Subject: Planning Application R/230/19/PL - Springfield House, Springfield Close, Rustington, BN16 2SZ - Objection

Further to the site notice seen for Planning Application R/230/19/P, we write to object to the proposed relocation and significant enlargement of the garage onto the eastern boundary and to the accommodation on the first floor of the garage. We own the neighbouring property to the east of the Application site and will be directly affected by the proposal.

Job Title	Springfield House		
Client	Castle Property Developments		
Drawing Name	Garage - Plan & Elevations		
Drawing Status	Planning		
Drawn by	DF	Date	Sept 19
Checked by		Date	
Drawing Scale	1:50 & 1:100 at A1		
Drawing No	Status	Revision	
181303/	09

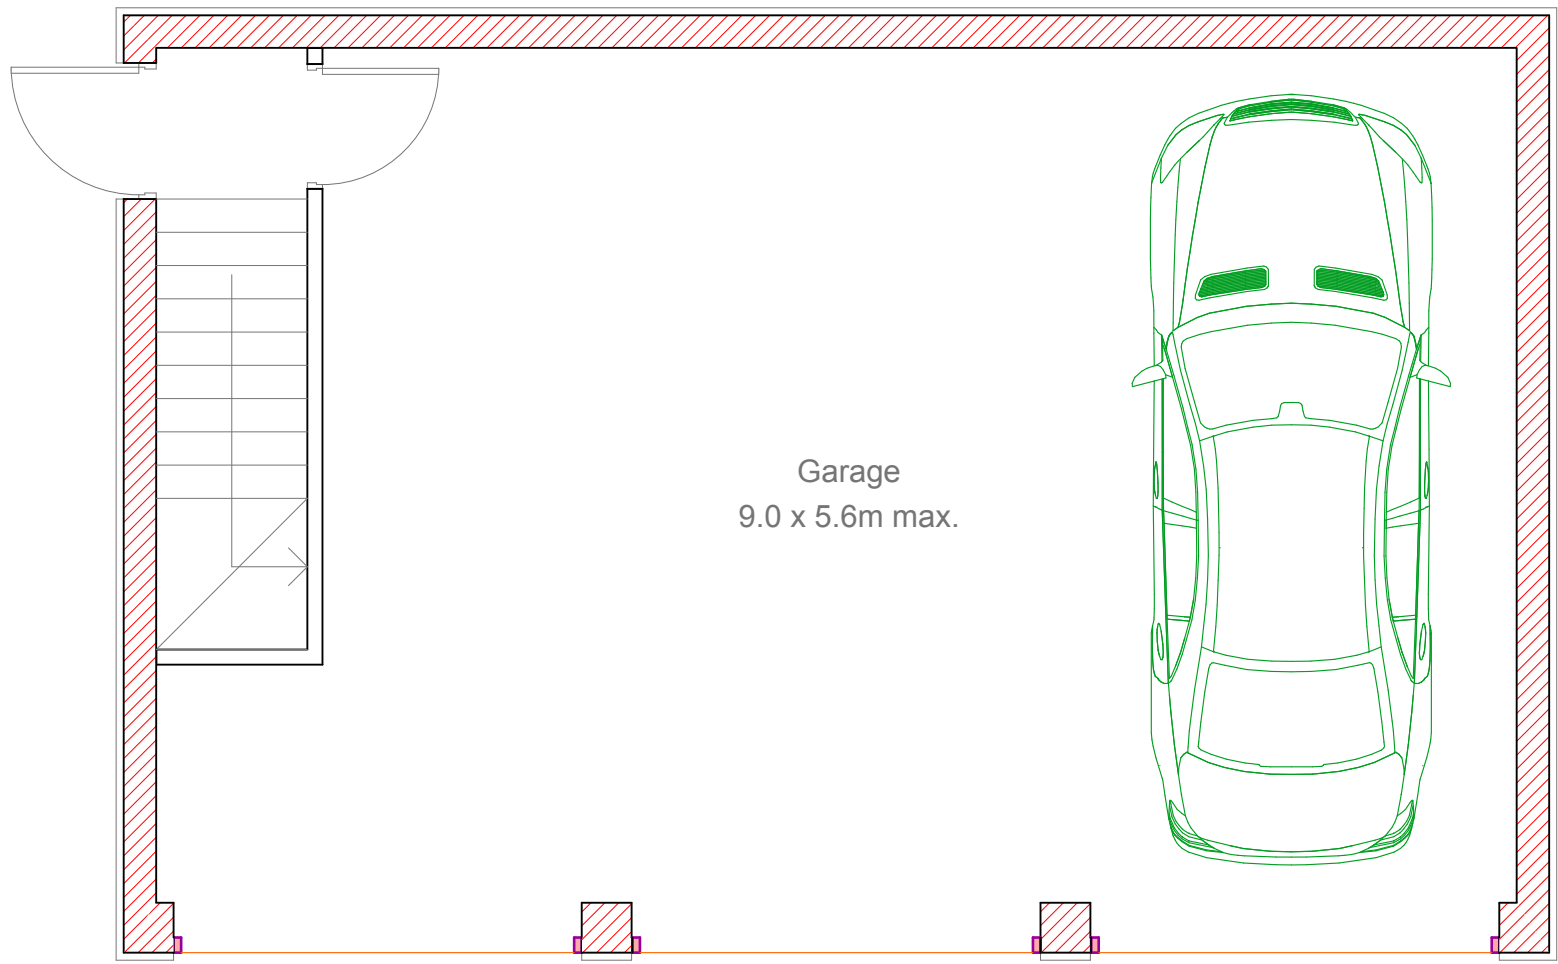
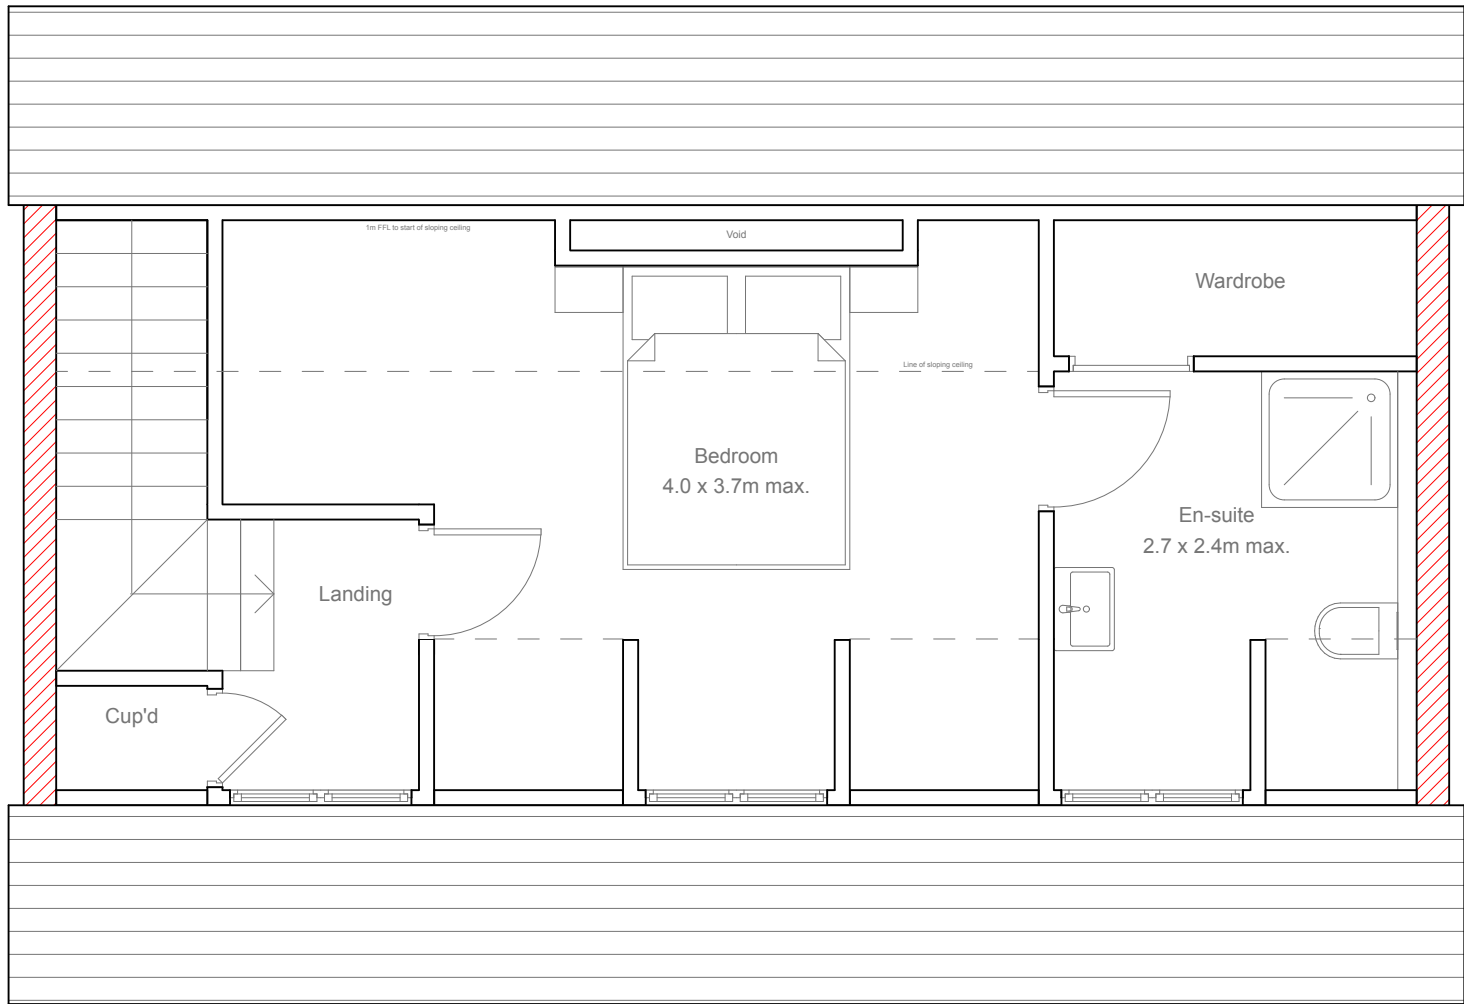
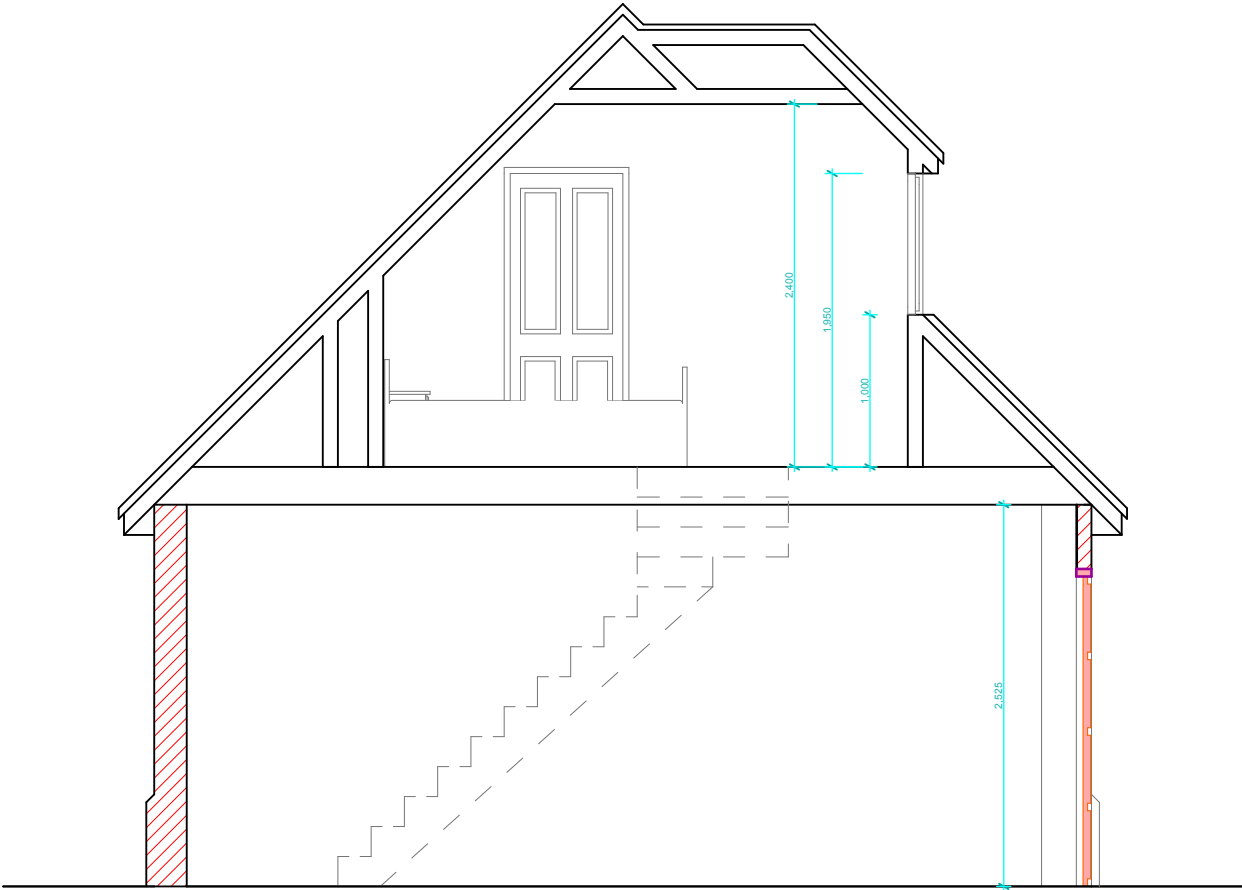
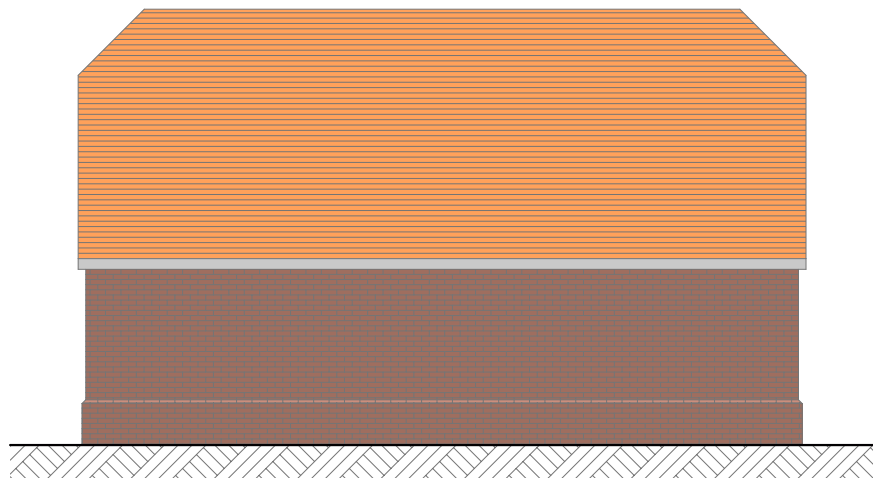
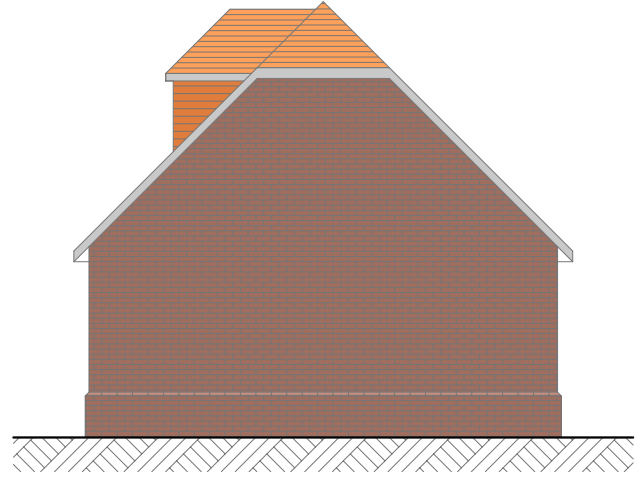
The proposed building has now increased dramatically to a triple garage and first floor accommodation from the approved much smaller double garage. Positioning the new garage block as proposed will create an uncomfortable relationship with our garden and provide anyone using the bedroom above the garages the ability to look directly in a south easterly direction into our garden from any one of the 3 dormer windows proposed. Applying for additional accommodation is unnecessary in itself given the size of the approved house, and the plans suggest that this could become a self-contained annexe separate from the house. This is completely at odds with the current Planning Permission.

We believe that the proposed building has both an overbearing and overlooking impact on our property, decreasing the ability to quietly enjoy our garden. The large gable will loom ominously over our eastern boundary and be a very hard edge to the current unencumbered views of the boundary trees. We believe that the proposed garage has been 'shoehorned in' to try to (just about) avoid the trees on the northern boundary, namely Trees 16 and 17. The previous siting of the garage fully respected the RPAs of T16 and T17, but the proposed large block appears to encroach into the RPAs to a more significant degree than the Arboricultural Report would appear to suggest. No details of foundation design have been provided, however the likely strip foundations will have an effect on these trees.

To conclude, we object to the siting, scale, massing and design of the proposed garage block and additional annexe accommodation for reasons of inappropriateness, significant overlooking, overbearing impact on our garden, likely impact on Trees 16 and 17, inappropriate landscaping provision to the site boundary and most importantly the loss of privacy to our property caused by the proposed new accommodation. We would respectfully ask that the Planning Application is refused.
